From: Andrew <andrew@o-l-ltd.co.uk>
Sent: 24 August 2019 15:31
To: _planningadvice
Cc: James Sims; john.hemingway@arcosconsultancy.com; Ronnie; Andy Richardson; mark@srcltd.com
Subject: Proposed Pack-house extension and relocation of staff parking (A1342)
Attachments: 329316_A3_Wastewater.pdf; 329316_A3_Clean Water.pdf; Anglian Water Comments.pdf

SHDC Ref: H14-0673-19

AW Site Reference:	149995/1/0064670
Local Planning Authority:	South Holland District
Site:	J O SIMS LTD PUDDING LANE PINCHBECK SPALDING PE11 3TJ
Proposal:	Proposed pack-house extension and relocation of staff parking
Planning application:	H14-0673-19

Site Block Plan as proposed

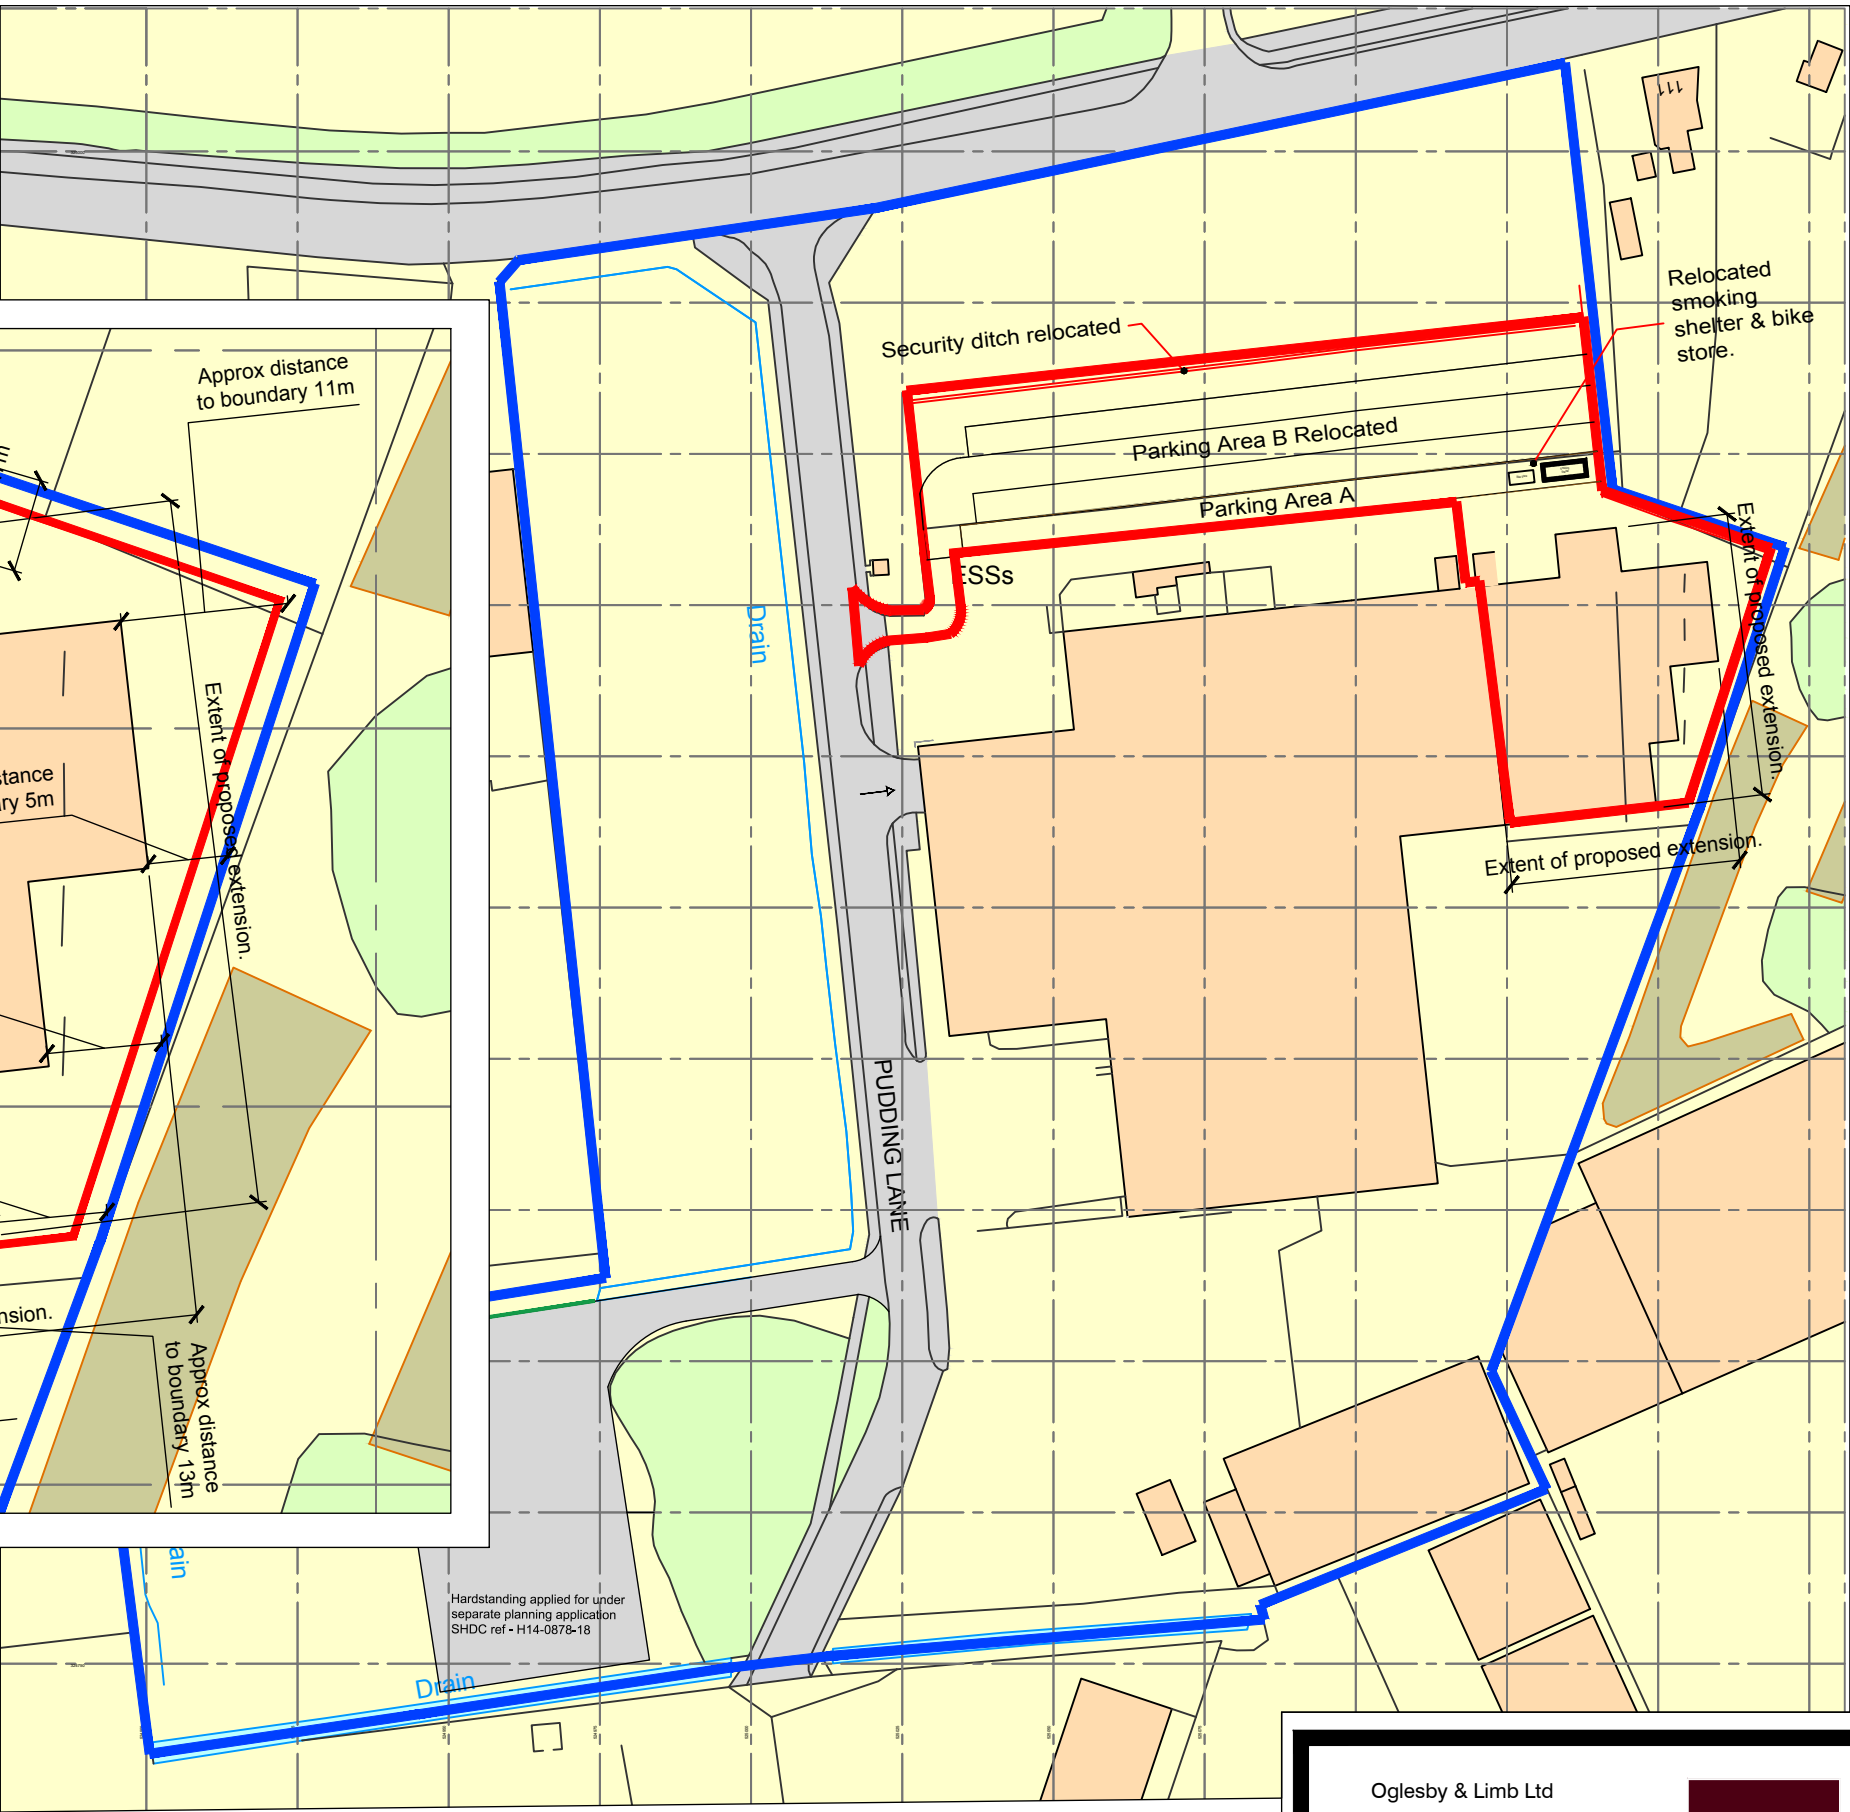
A foul water main is shown within Pudding Lane and enters the application site at its vehicular access point direct from the road. The plan shows a public pumping station within the car park area of the applicant's site from which a pumped rising main appears to head north before turning east along the south edge of Wardentree Lane. The pumping station covers have been identified on site (they are locked and are therefore inaccessible except presumably by Anglian Water's own operatives). The rising main must already run beneath the car park but only along the very edge nearest Pudding Lane. The proposed building works (pack-house extension) are remote from this and will therefore have no impact. The works to relocate car park B as an extension of car park A are closer to the pumping station but no closer than the existing access area / car park in which it already stands. Whilst the car park is being extended northward it is not believed that this will be of significant detriment to the rising main since the finish to the new car park area simply replicates what is already there. The main appears to skirt the west edge of the site against the very west edge of the car park. The applicant does not therefore believe that the works will impact upon the main or pumping station. The correspondence relates to dwellings within 15m of the apparatus however our proposal does not involve buildings of any type within 15m, so this does not appear entirely relevant.

The development site is within 15 metres of a sewage pumping station. This asset requires access for maintenance and will have sewerage infrastructure leading to it. For practical reasons therefore it cannot be easily relocated.

The site layout should take this into account and accommodate this infrastructure type through a necessary cordon sanitaire, through public space or highway infrastructure to ensure that no development within 15 metres from the boundary of a sewage pumping station if the development is potentially sensitive to noise or other disturbance or to ensure future amenity issues are not created.
